From: [Holly Duncan](#)
To: [Dusty Pilkington](#)
Subject: RE: BL-17-00021 Teanaway Ridge
Date: Tuesday, December 12, 2017 10:23:17 AM

When I click on this link it comes up as Galloway BL-17-00024. I have some comments on the BL-17-00024:

PRELIMINARY BOUNDARY LINE ADJUSTMENT EXHIBIT		
PREPARED FOR UNIONVILLE RANCH, LLC A PORTION OF SECTIONS 5 AND 6, TOWNSHIP 19 NORTH, RANGE 17 EAST, W.M.		
KITTITAS COUNTY	WASHINGTON	
DWN BY DLP/GW	DATE 11/2017	JOB NO. 141361
CHKD BY GW	SCALE 1" = 200"	SHEET 1 OF 1

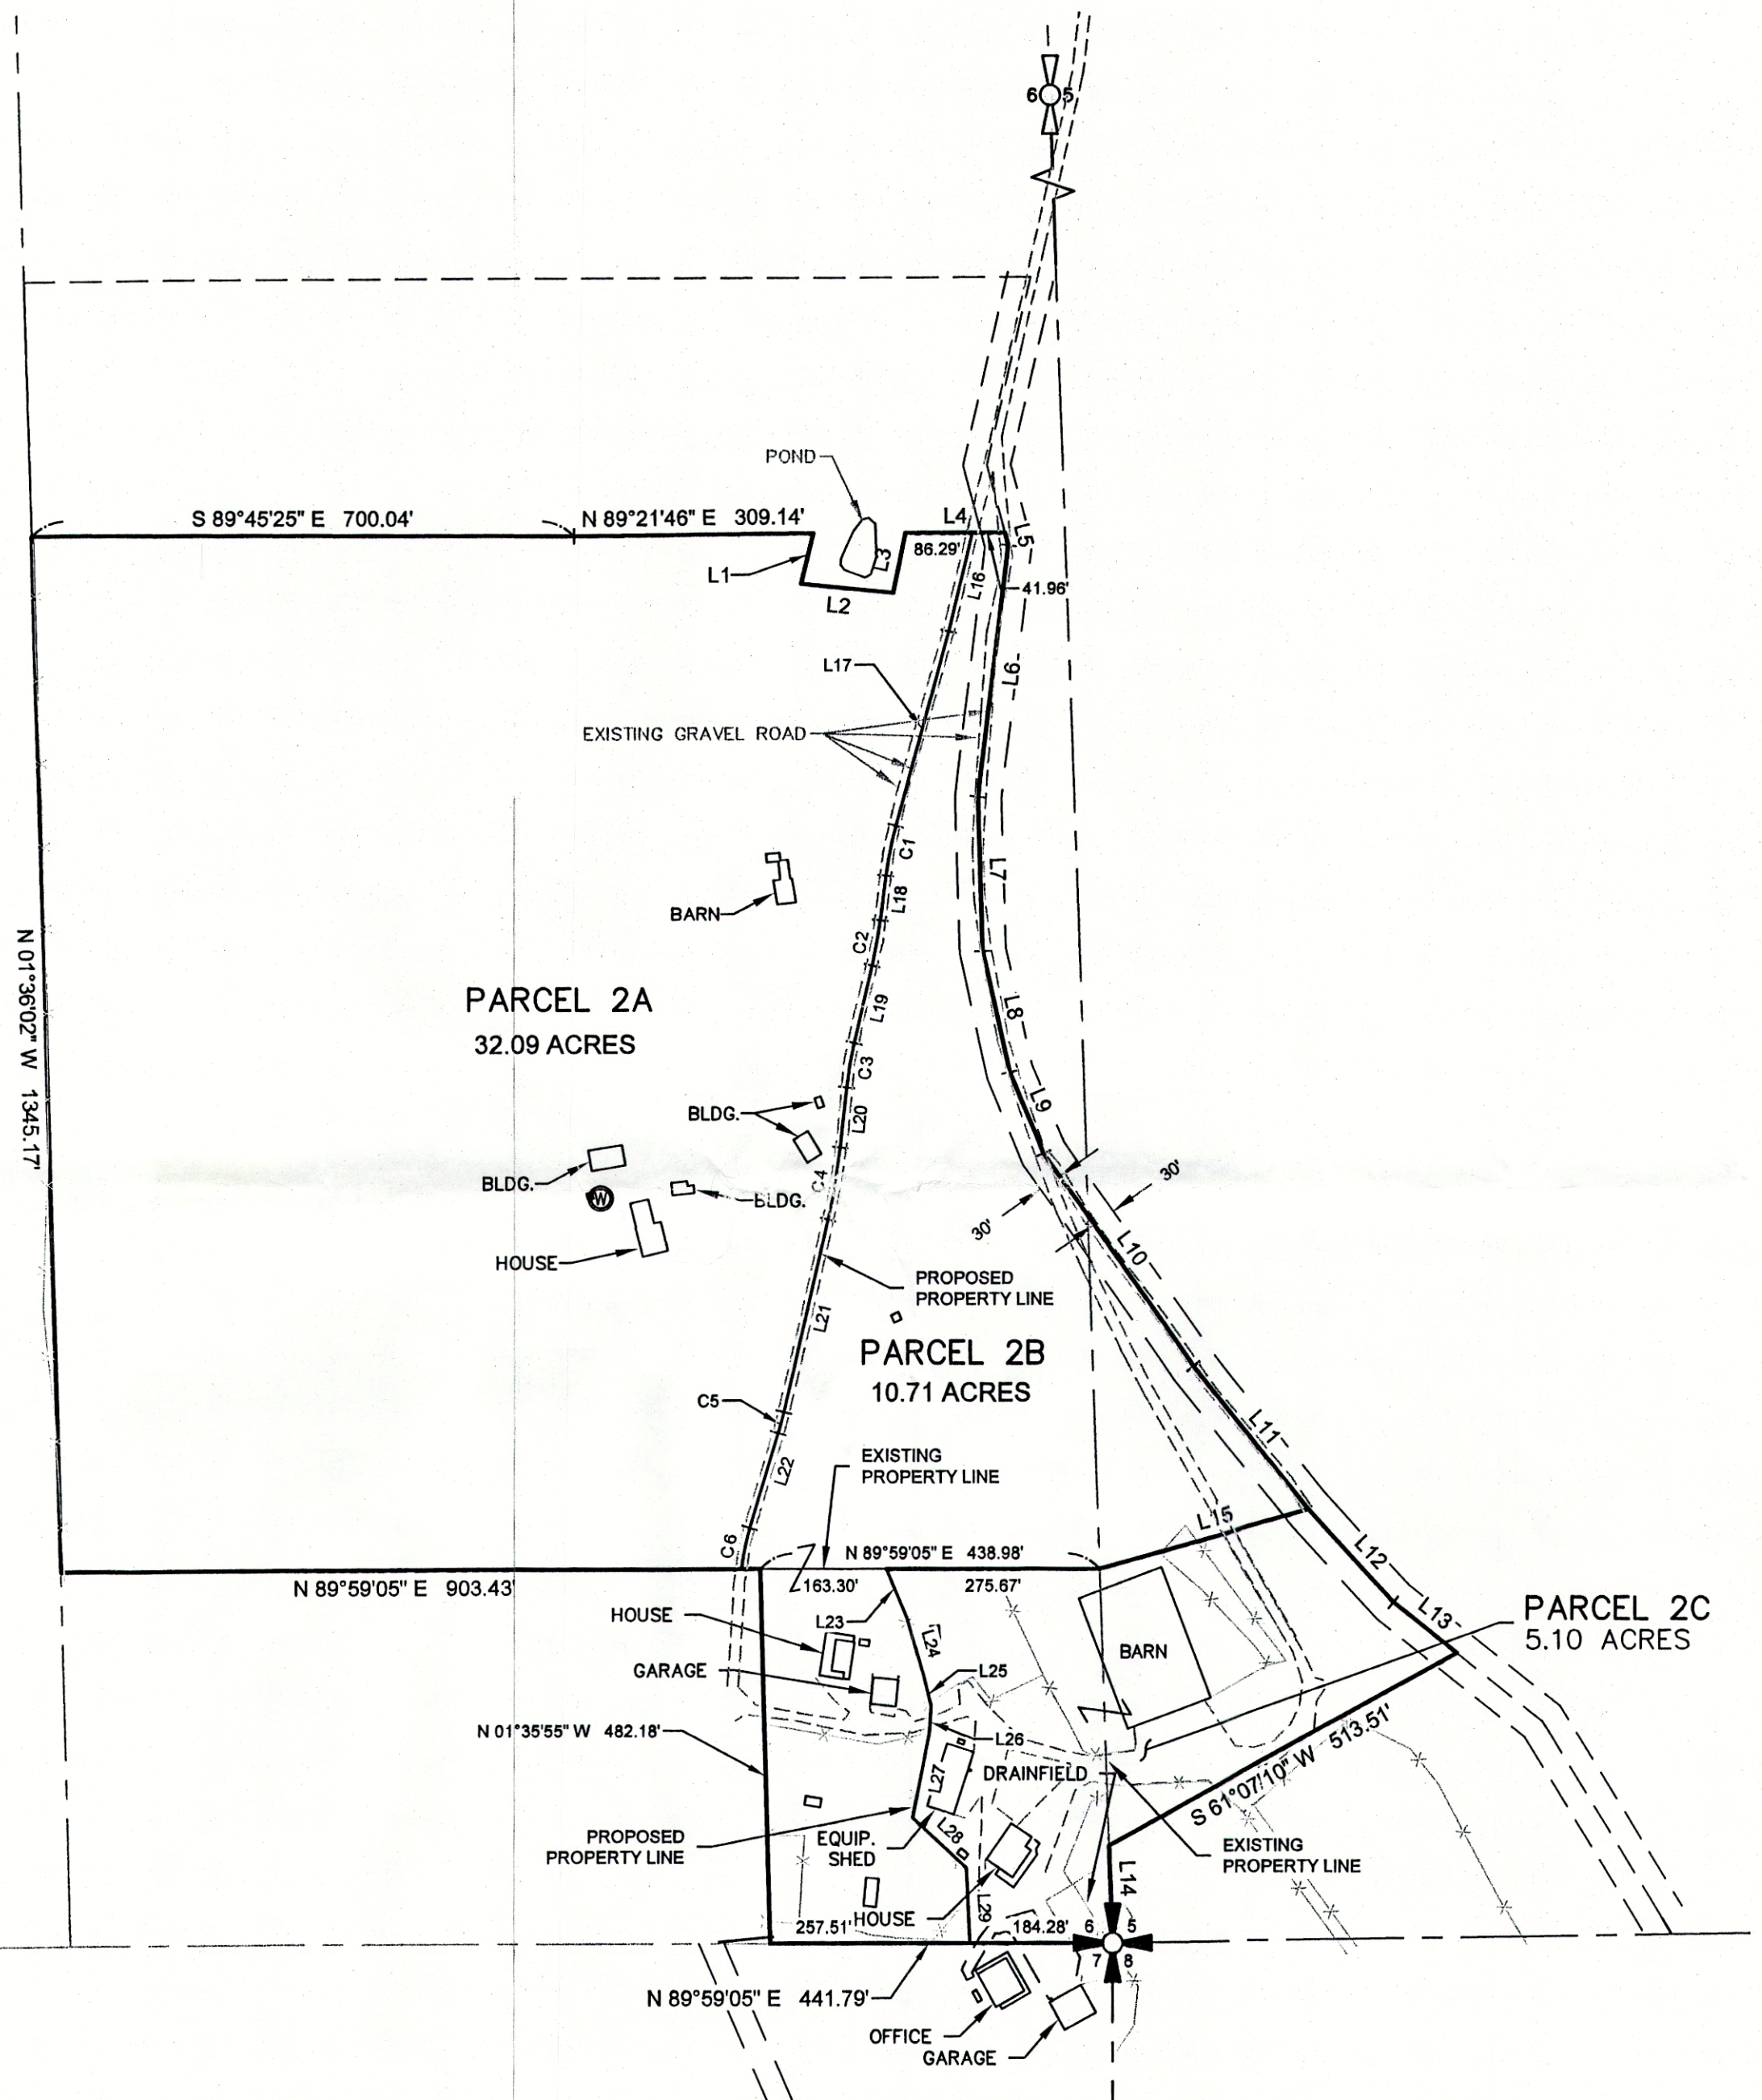
1. There is an existing wellhead near the proposed property line between parcels 2B and 2C that is not shown in the Encompass drawing. According to the records I have, the well head not shown looks like it is right next to the proposed property line which is following a fence line. I will need this existing wellhead included in a drawing. The proposed property line has to be at least 50 feet from the existing well.
2. I also need to see the location of the existing drainfield for the house on the proposed parcel 2B. It is also not shown.
